Your reference: SSD-8950984
Our reference: DOC23/993628

Heritage NSW - Advice on Environmental Impact Statement (EIS) - State Significant Development (SSD-8950984) – Burrendong Wind Farm

11 December 2023

Figure 6-8: AHIMS sites within and in proximity to the Project Site

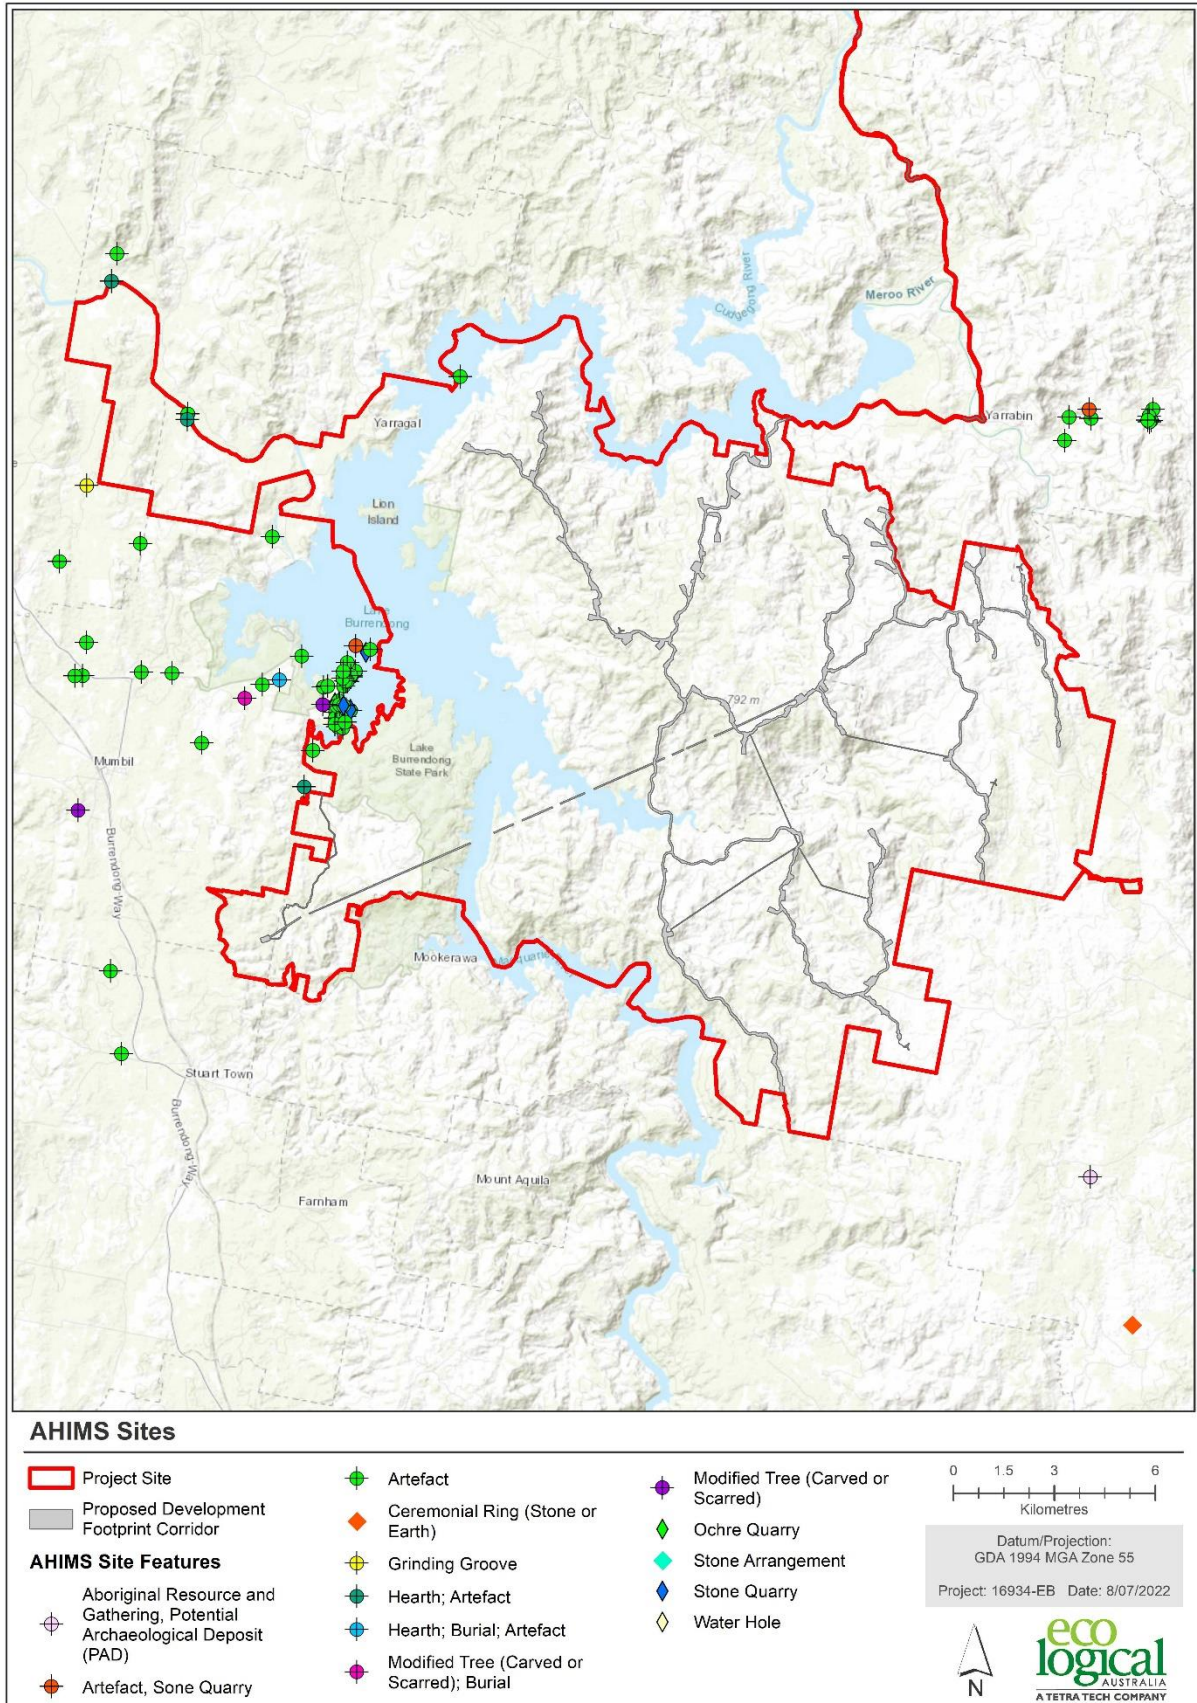
- Section 4.1 notes that the AHIMS search included in the ACHAR identified eight (8) restricted sites with only three (3) confirmed to outside the project site. Confirmation of the interaction of restricted sites with the study area is required. This information can be obtained by emailing ahims@environment.nsw.gov.au, and providing the list of restricted sites in question and a shapefile your study area. Please include the results of this request in the revised ACHAR.

Figure 1 - Figure 5 show the areas surveyed and the refined Development Footprint and Development Corridor.

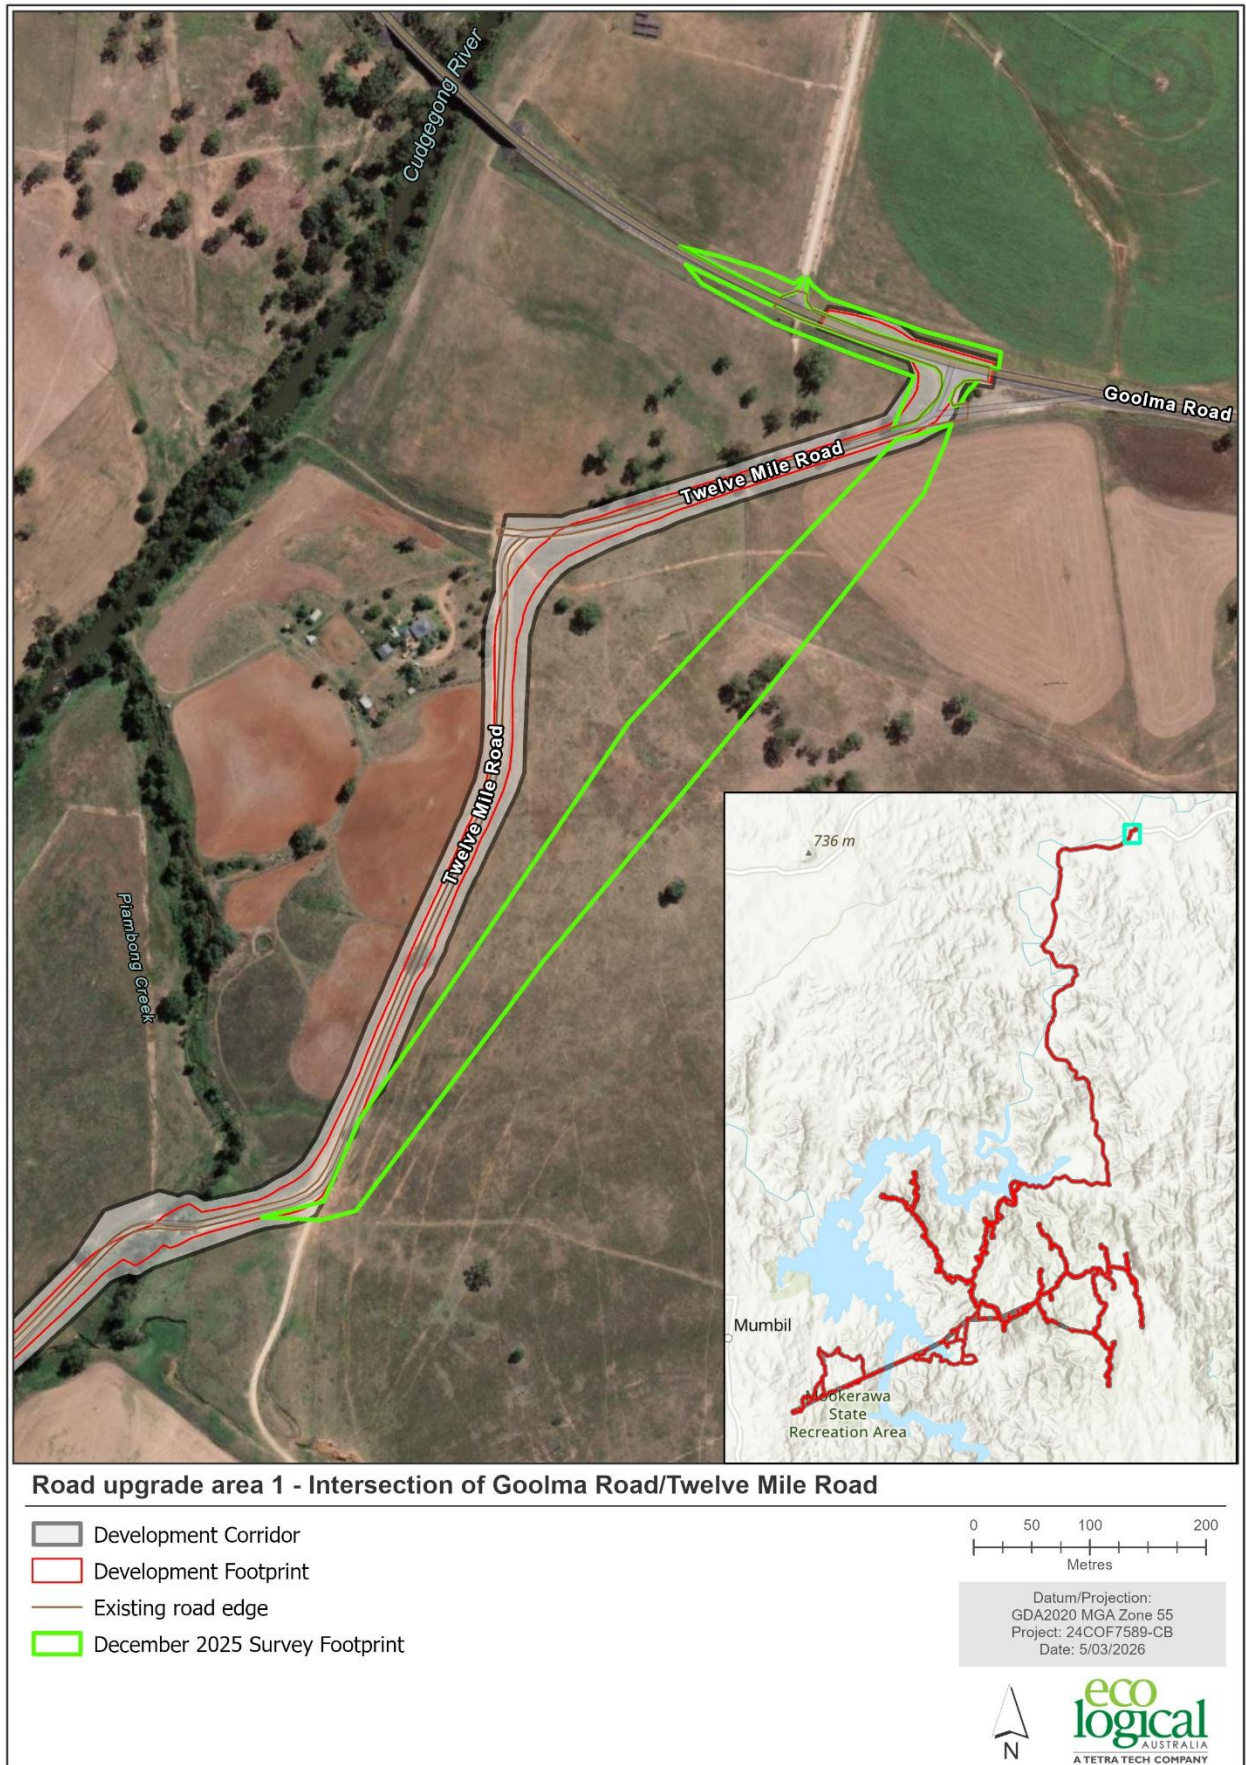
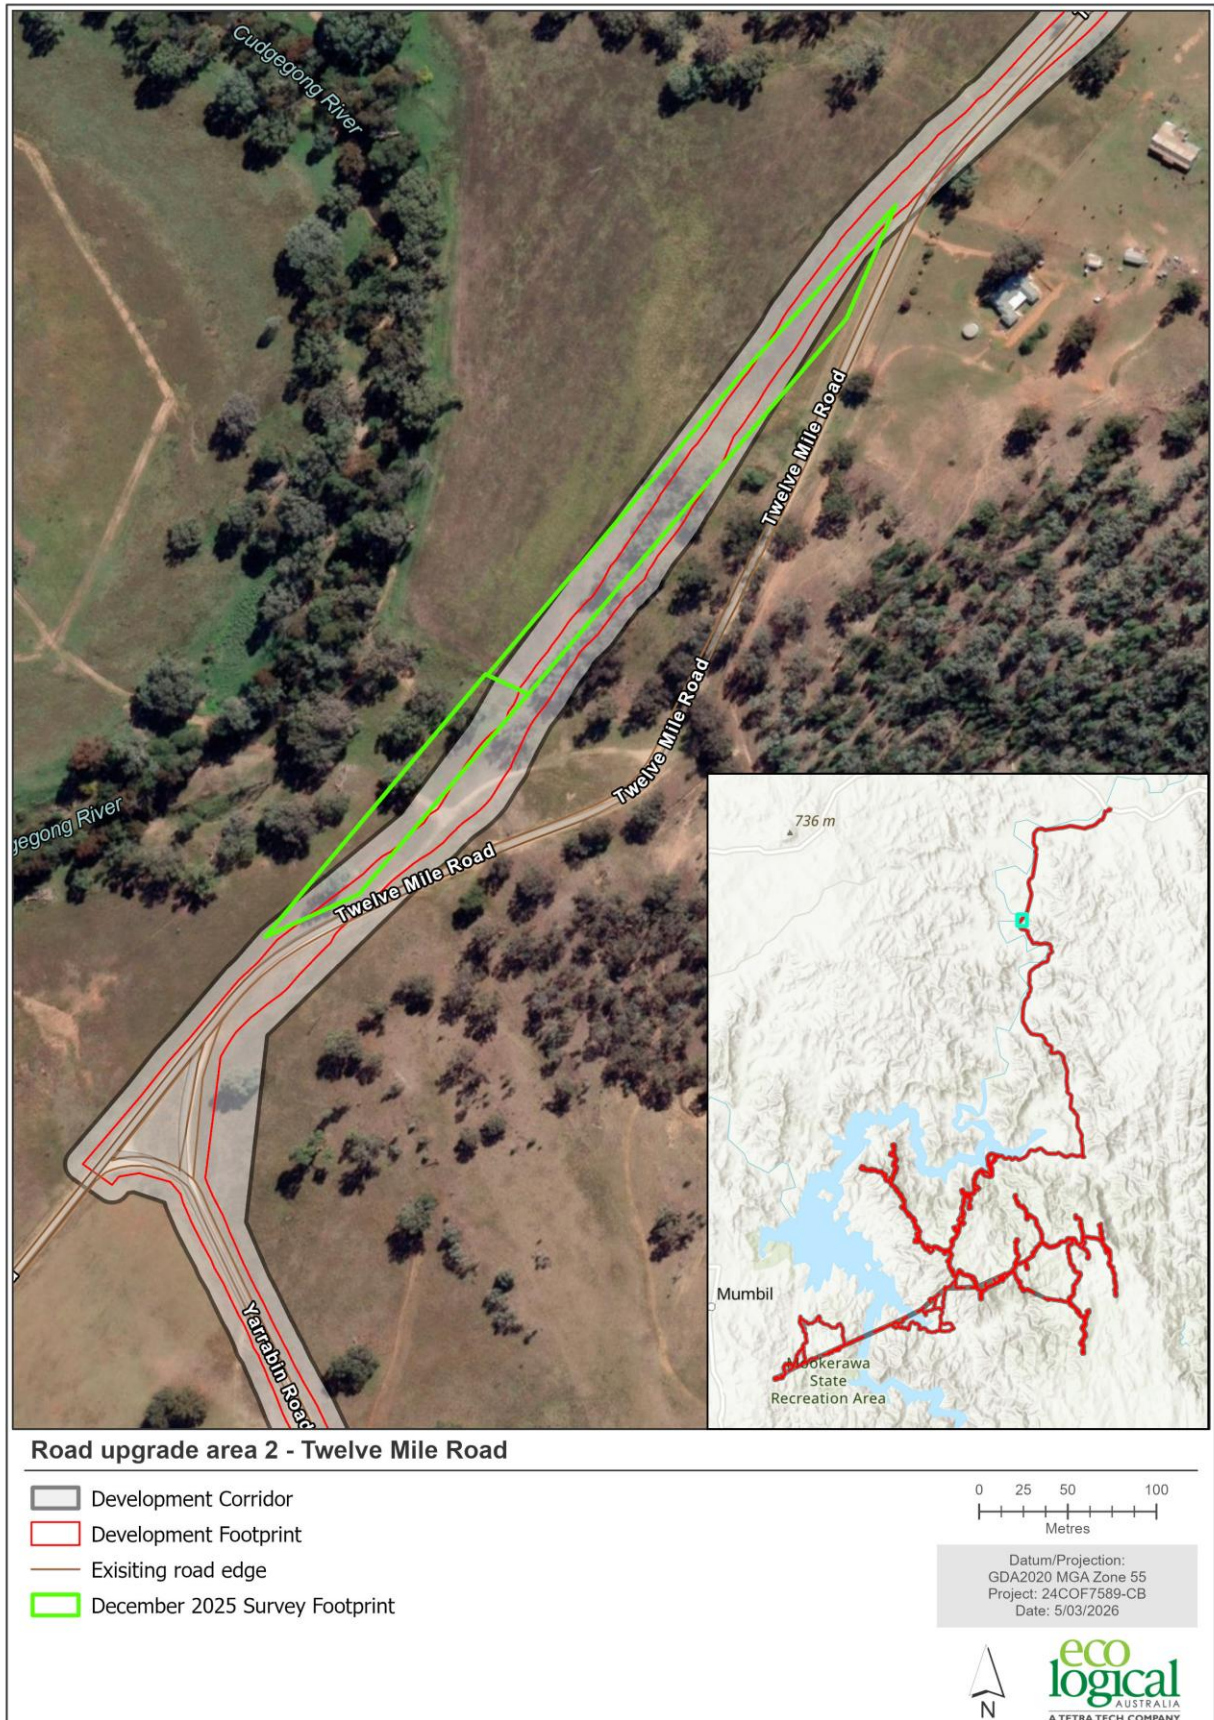
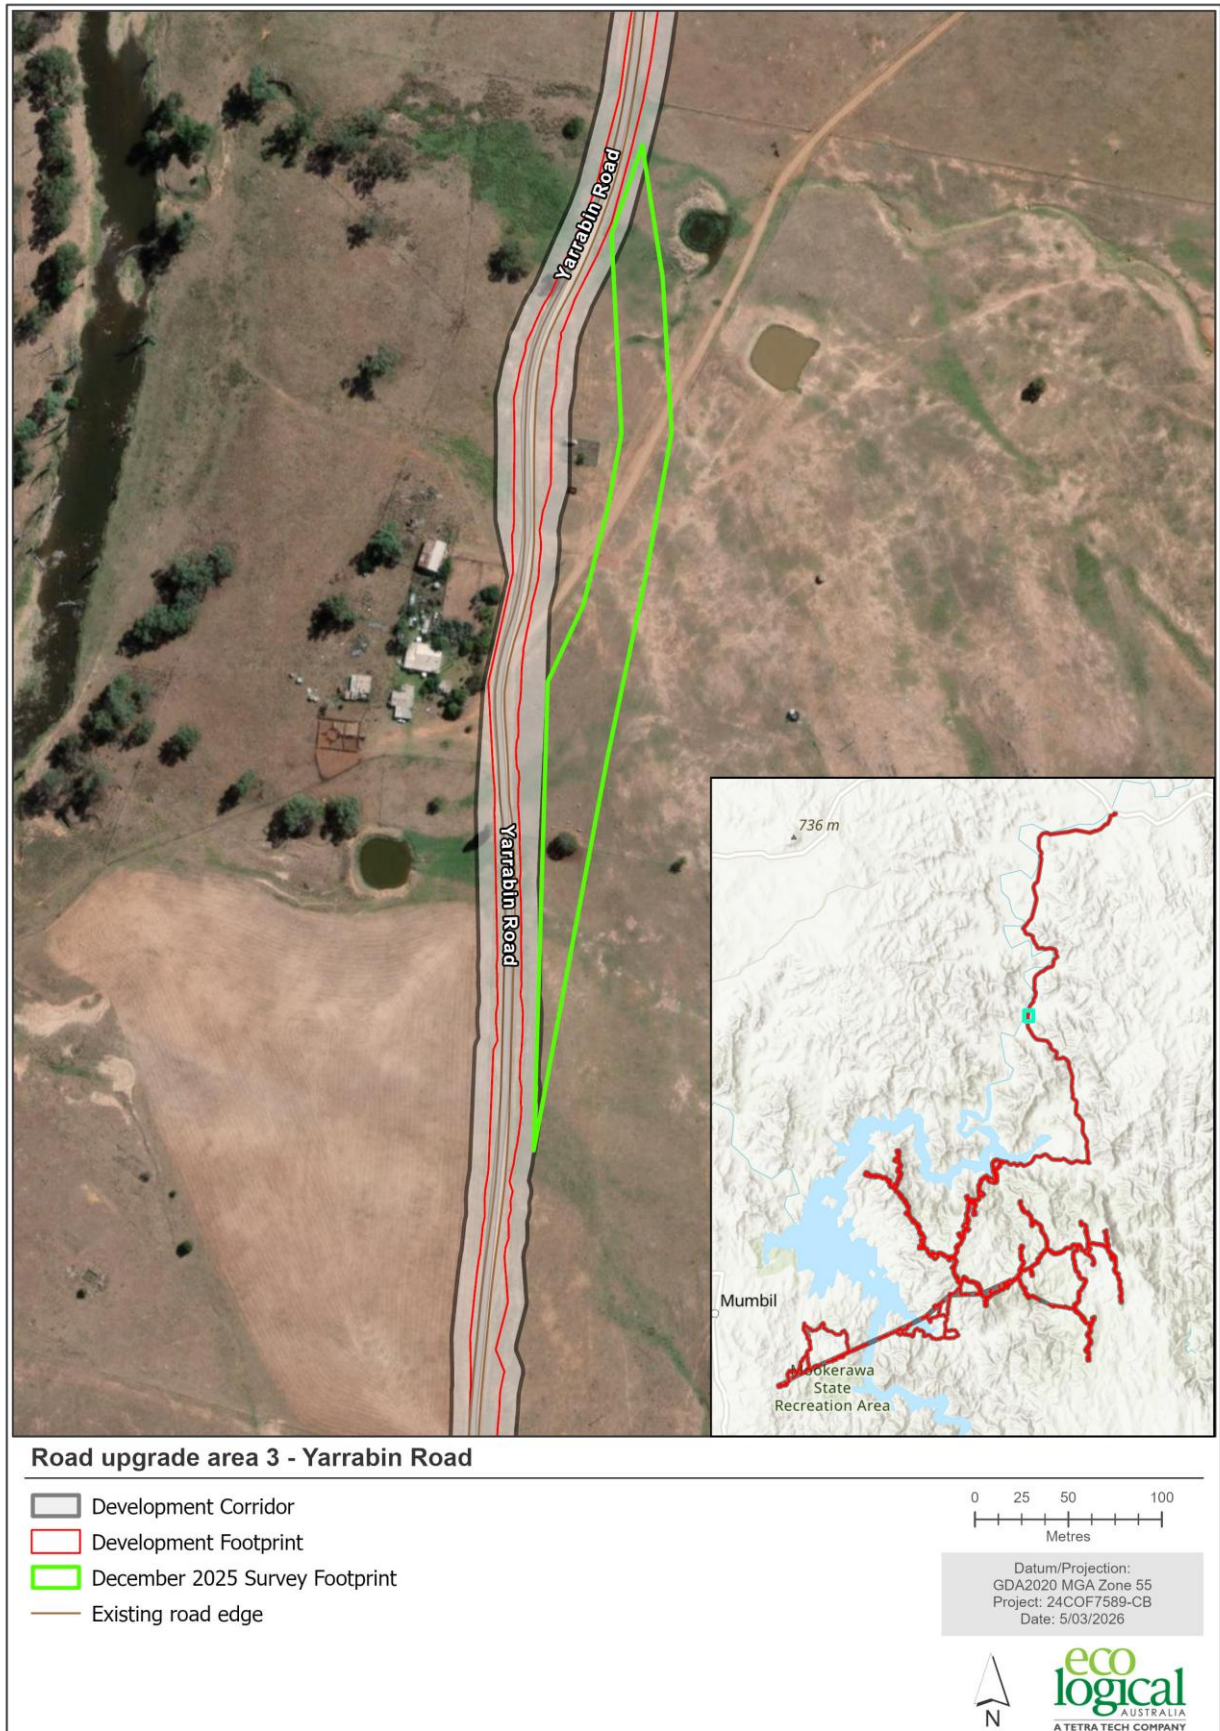
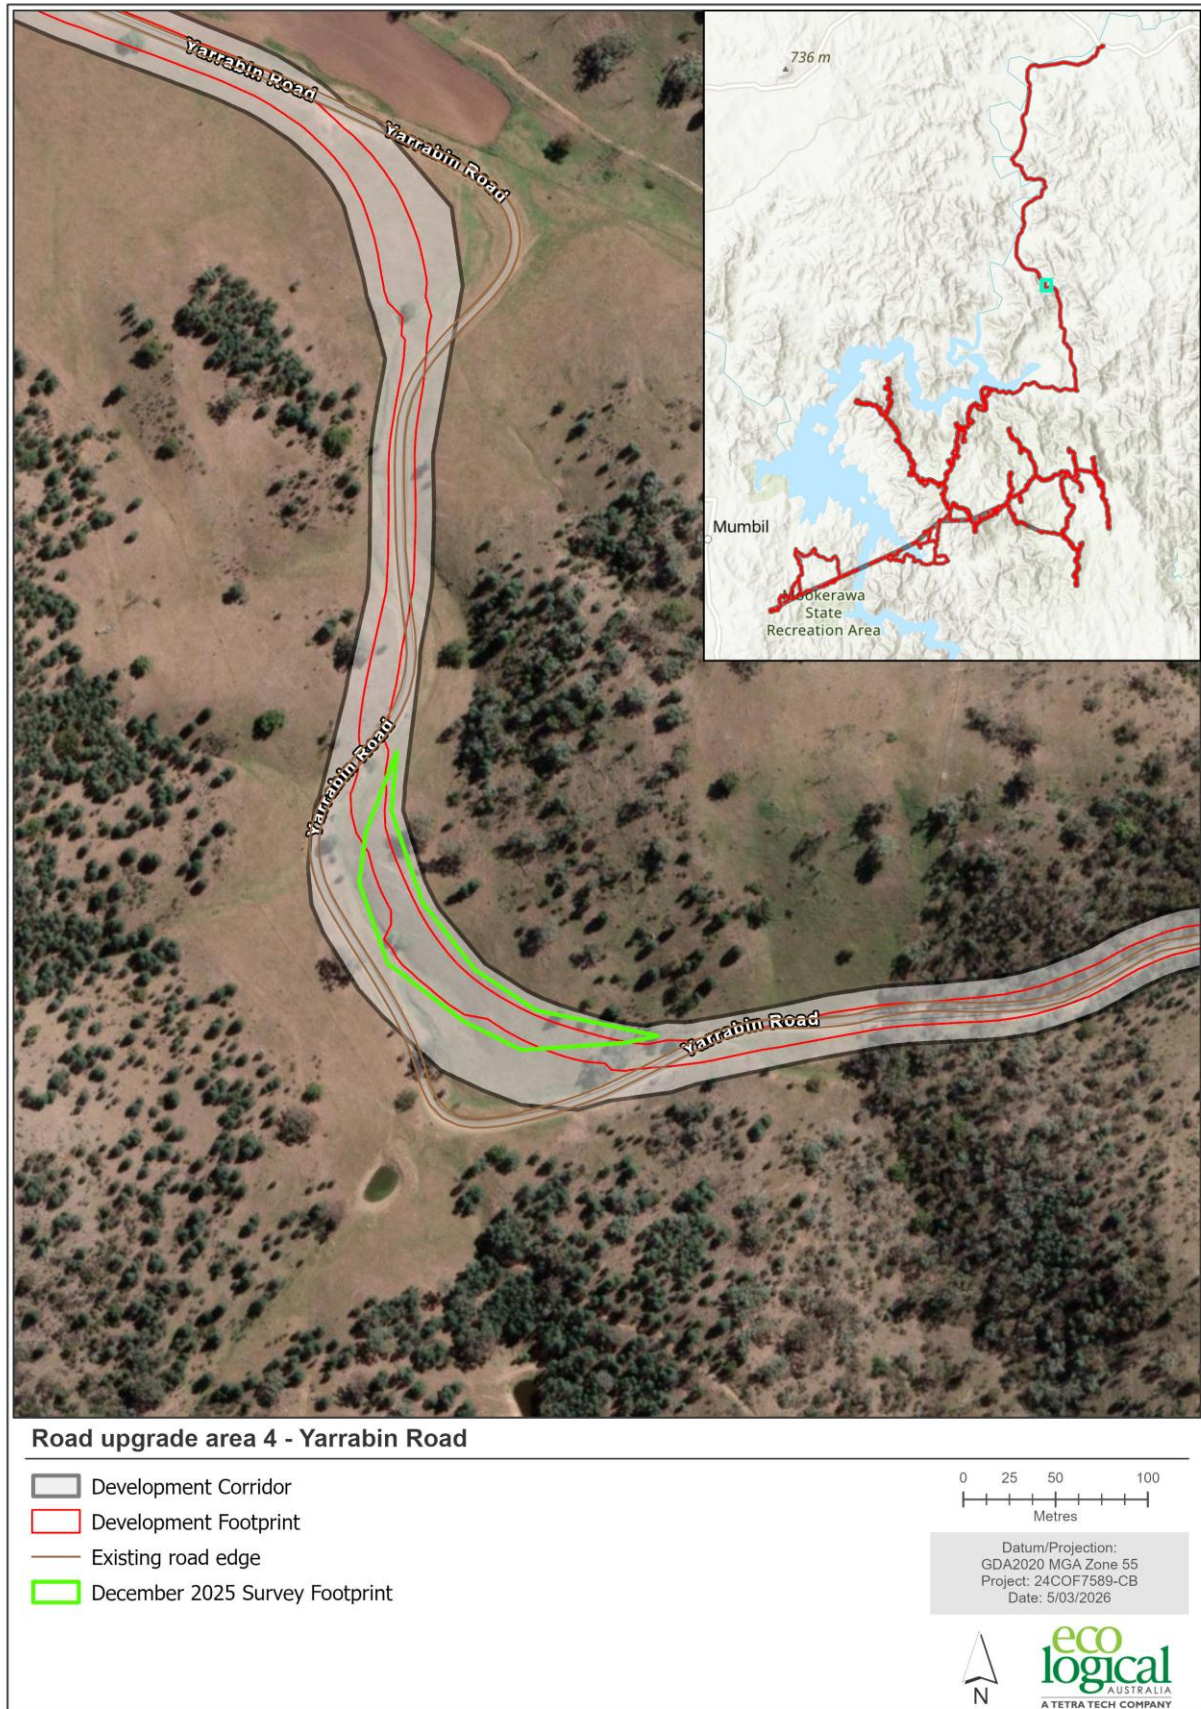
- The footprint of works identified in the EIS includes a transport corridor subject to road upgrades. Please clarify if the approval for these impacts is a part of SSD 8950984, as the ACHAR did not include these areas within the assessment. If the transport corridor works are a part of the SSD 8950984 approval, they will need to be included in the Aboriginal Cultural Heritage Assessment.
- Section 6.8 of the EIS states 94 of the 102 sites identified on the AHIMS search were located in the assessment area. This is in contrast to Section 4.1 of the ACHAR which states not sites are within the project site. Please clarify this information.
